Our reference: R/2023/4

Your reference: MP06_0265-Mod-4

Subject: Youth Hotel and Archaeological Centre - MP06_0265 Mod 4 - Advice on Modification

LEVEL ONE PLAN

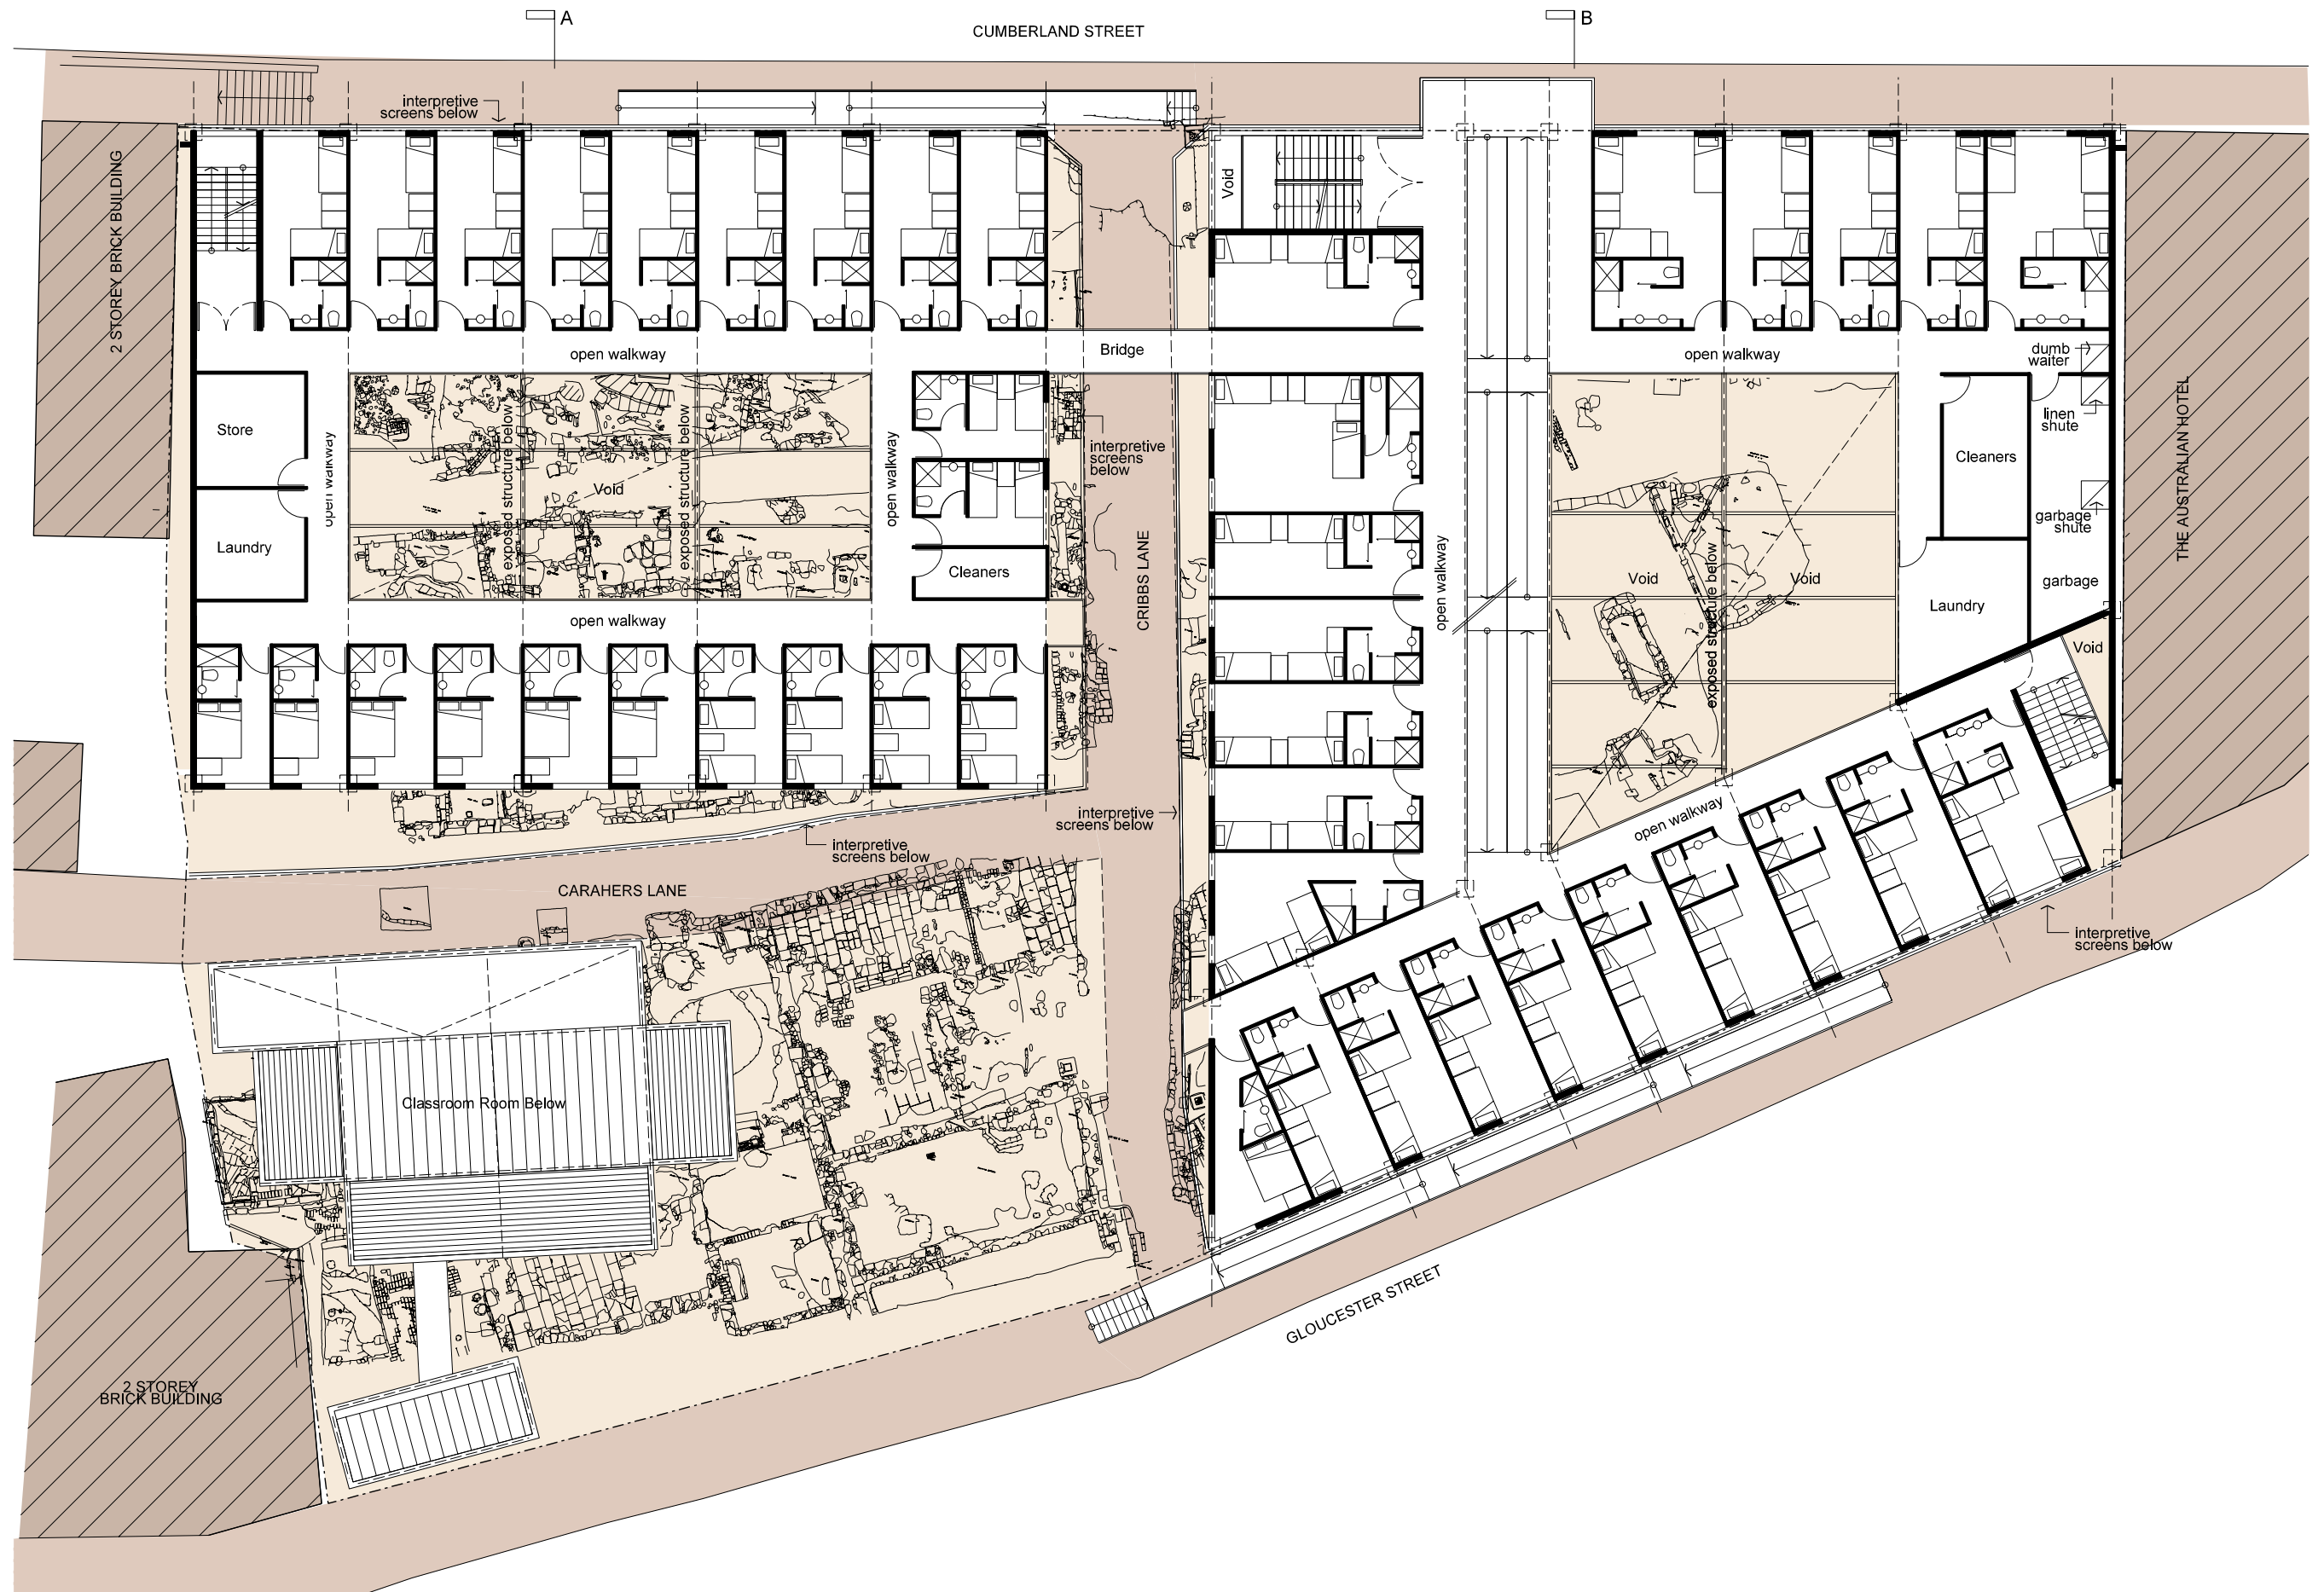
1. A floor plan of both Level 1 and Level 3 outdoor spaces must be included.
2. The Plan talks about terraces "mostly used by guests". The Plan must detail the measures in place, given the premises proposes to be licensed, to monitor under aged drinking and secondary supply.
3. Level 3 is proposed to be used for "6 special events" a year, extended to 1am. How is this recorded?
4. Further details on how an on-premises licence will be managed is required. Given the most typical on-premises is for an associated food premises, what food is proposed to meet the Liquor and Gaming primary purpose test and how will the Responsible Service of Alcohol requirements be managed?
5. Measures that will be taken to address noise complaints must be included in the Plan.
6. Details of CCTV must be addressed.
7. Details of security to be provide on a regular, or special event nature are to be included.

LEVEL THREE PLAN

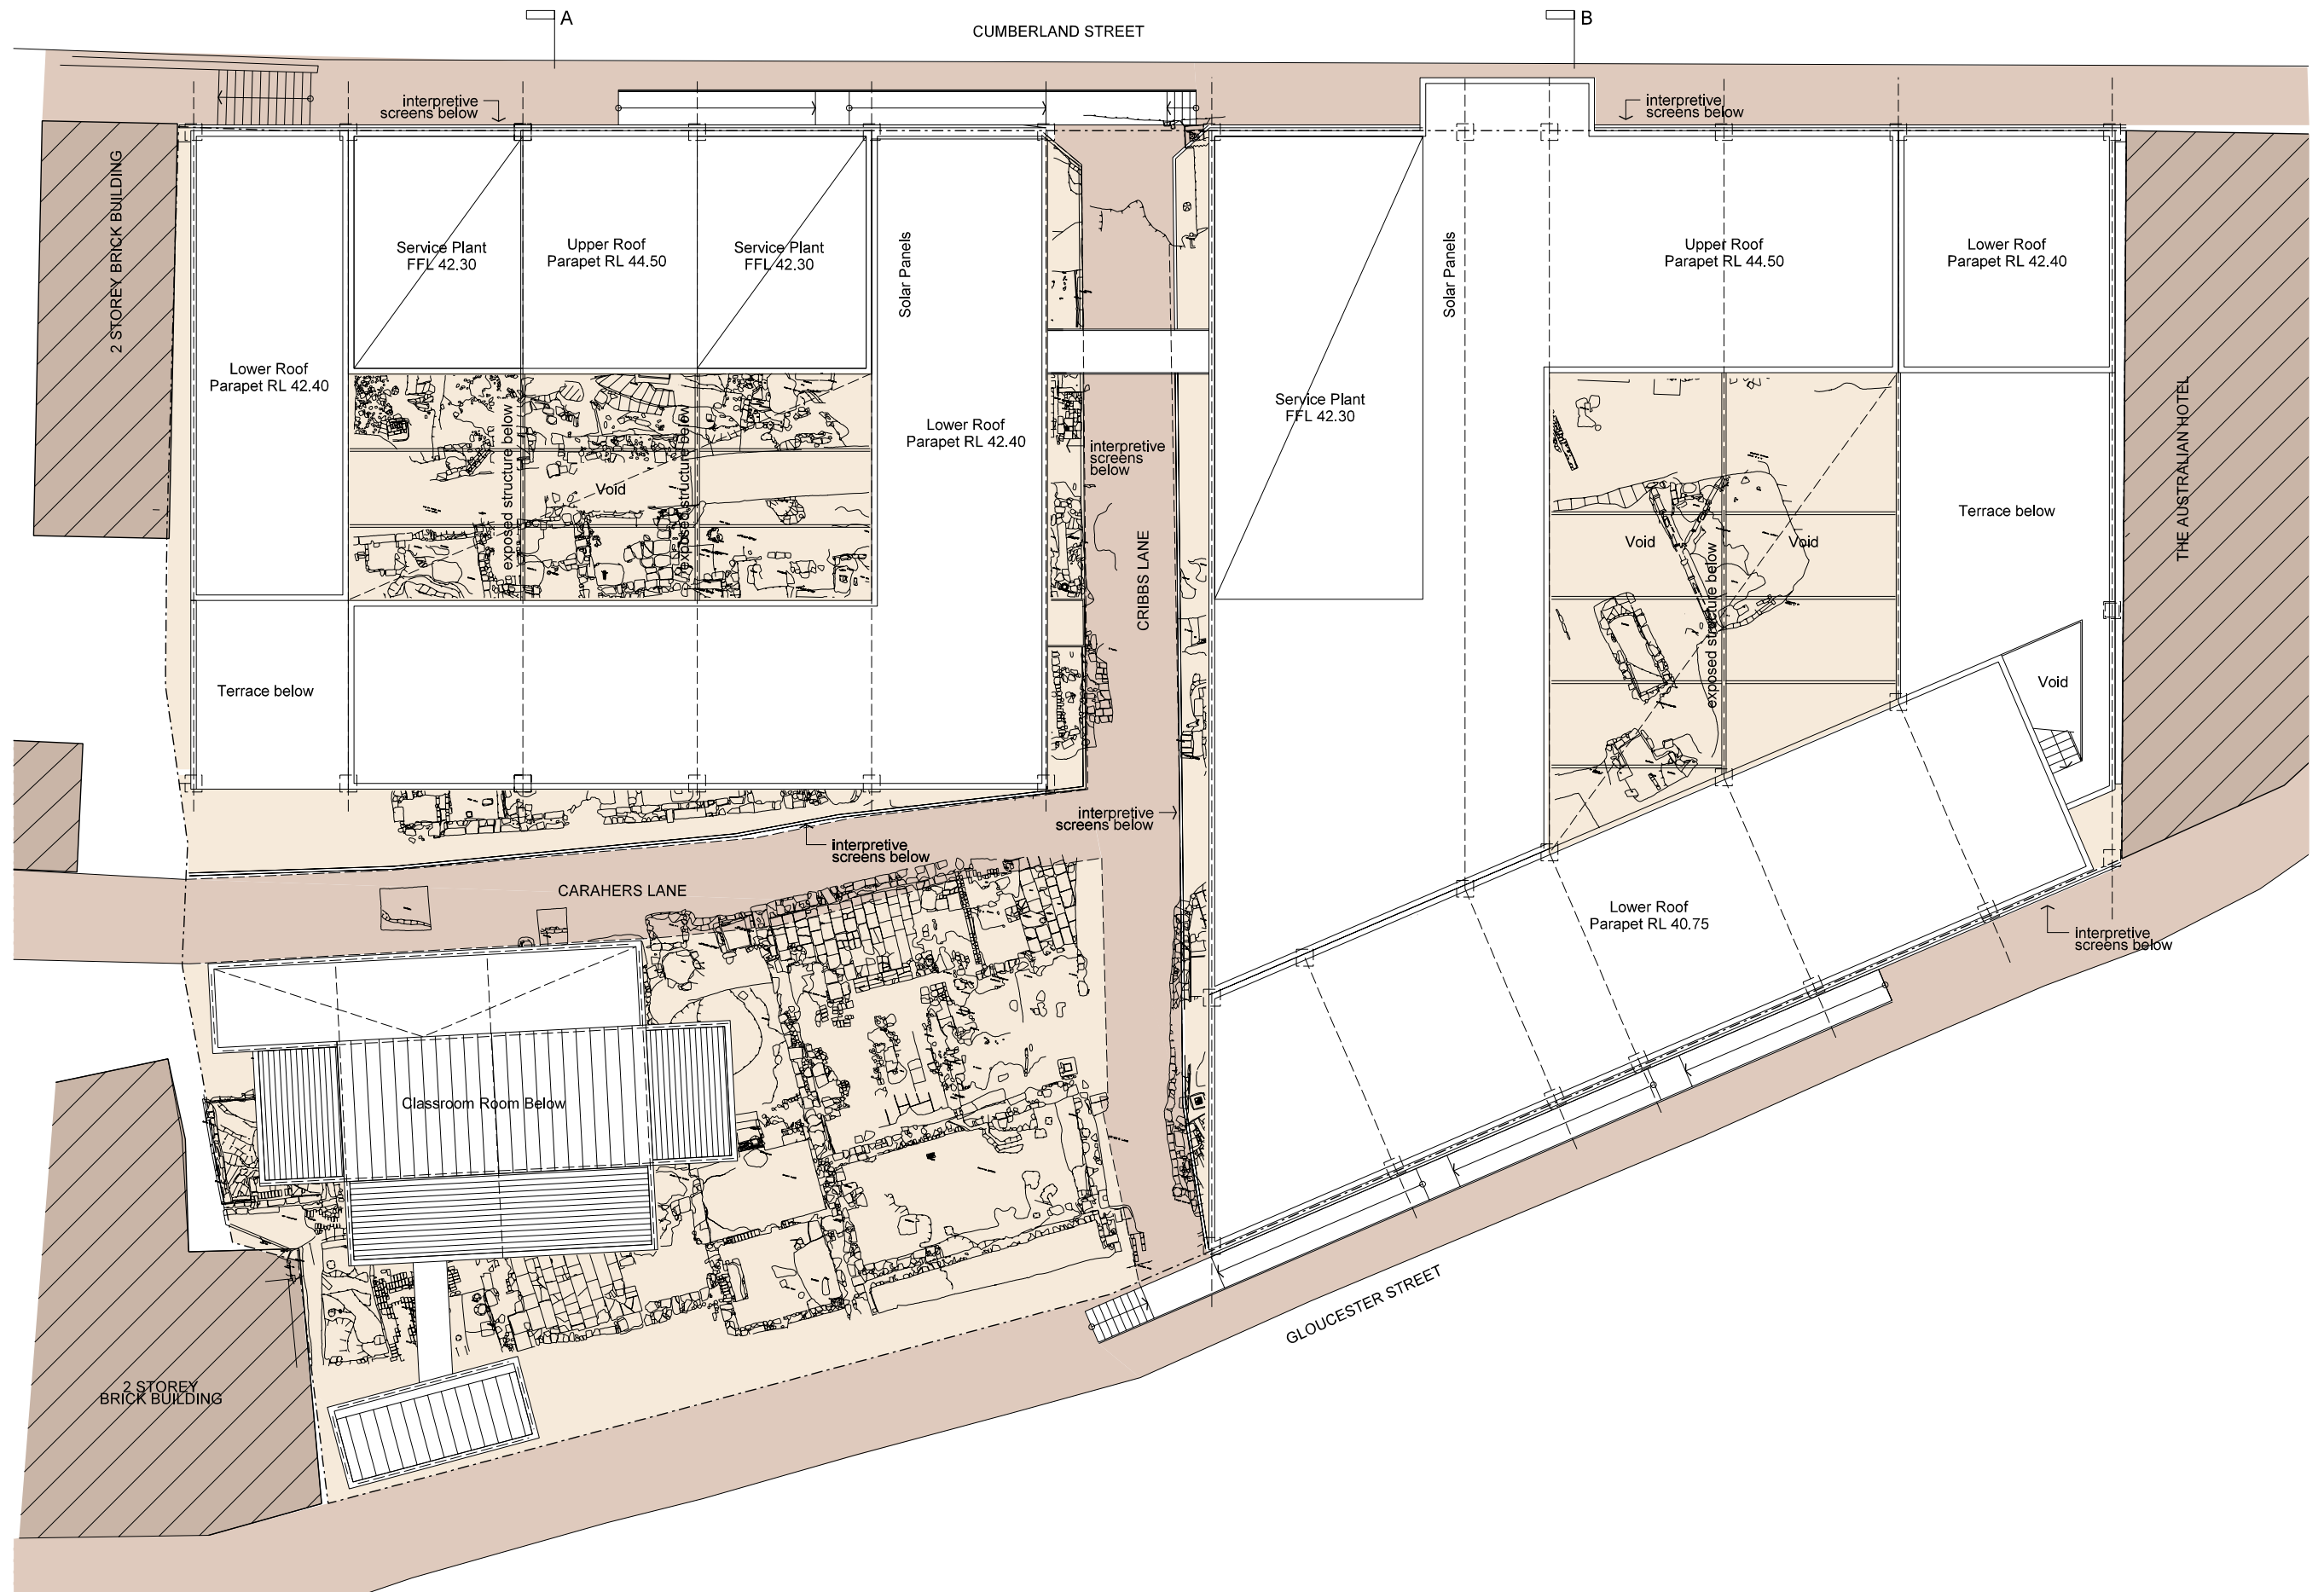
The notice of exhibition documents state that the modification is seeking to extend the hours of use for the outdoor terraces to 12am Monday to Sunday. It also states that the terrace will be used for live and amplified music. The acoustic report prepared by acoustic Logic (REF: 20220606.1/0806A/R0/PF dated 8 June 2022) has assessed noise from patrons and music being played through the proposed speakers. The noise predictions at the receivers are based on the speakers being operated only up until 10pm. There has been no assessment

of noise that may be generated as a result of live entertainment on the level 3 terrace.

The acoustic report should assess all noise generating activities associated with the use of the terrace, including live music during the proposed times of use as per the applicants notification. The City is unable to provide any further advice until such acoustic assessment is conducted.
